PROJECT NAME: **C.I.G. Preliminary Plat (P-07-59)**

**STAFF REPORT
C.I.G. PRELIMINARY PLAT**

TO: Kittitas County Hearing Examiner
FROM: Kittitas County Community Development Services Staff
RE: C.I.G. Preliminary Plat (P-07-59)
DATE: December 11, 2008

**C.I.G. PLAT**

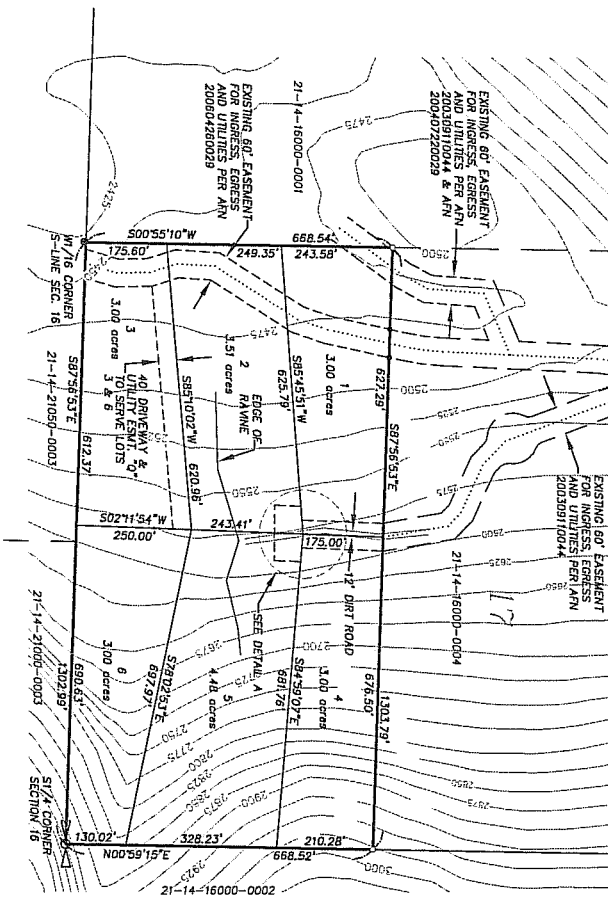
2. Anna Bell Drive: The entire access from the plat to Salmon La Sac Road shall be shown on the plat, or the vicinity map improved. Anna Bell Drive shall be identified on the face of the plat.
